Application H03-0908-19
Location Caultons Field west: Littleworth Drove Deeping St Nicholas PE11 3AE
Proposal Details of Interpretive Report on Ground Investigation Report (Condition 11 of H03-0331-16)

I have reviewed the Nicholls Colton Group letter dated 15th November 2019 ref G19102-LR 'Residential development at Littleworth Drove, Deeping St Nicholas - Localised elevated PAH' and make the following comments:

Title:
Exploratory Hole Location Plan.

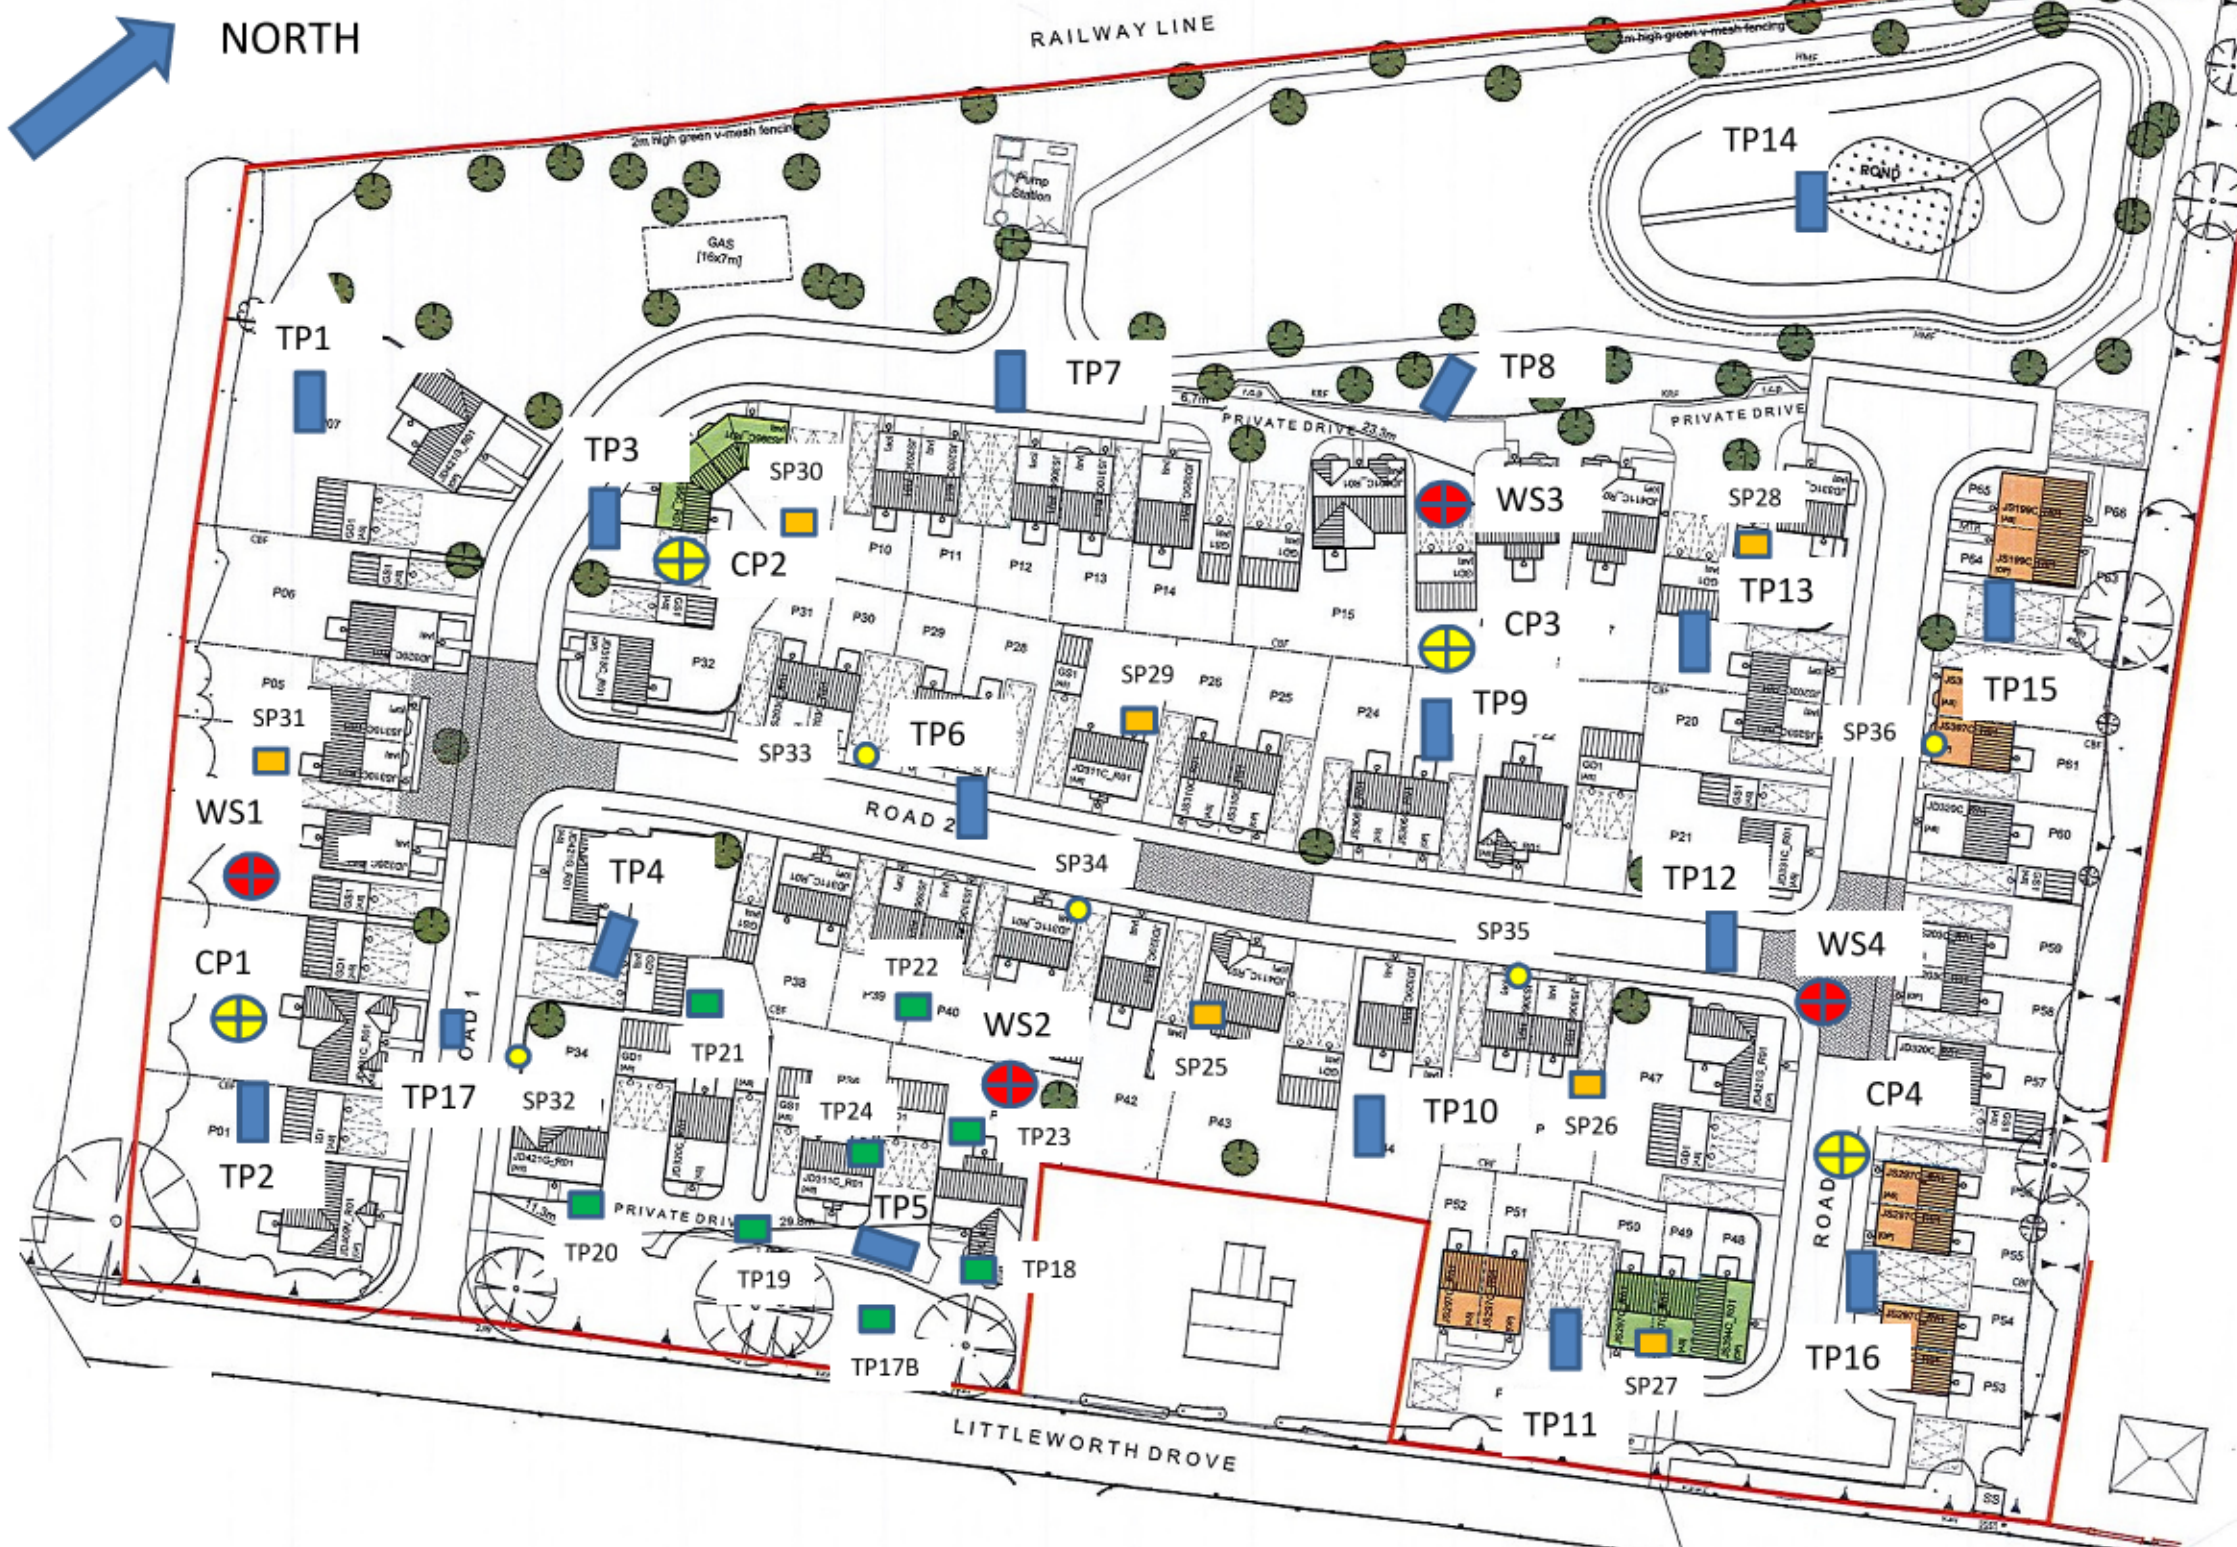
It is not possible to recommend discharge of condition 11 of H03-0331-16 at the current time. An area of elevated PAH's has been identified. It is proposed that topsoil will be stripped and discarded from this area, and that there will be a 1m land raise which will provide a barrier to prevent future exposure. The methodology is acceptable in principle however it will need to be specified in a remediation method statement and appropriate validation undertaken. Section 19 of the August 2019 report ref G19102-IFR recommended a program of ground gas monitoring, which does not appear to have been undertaken at the current time.
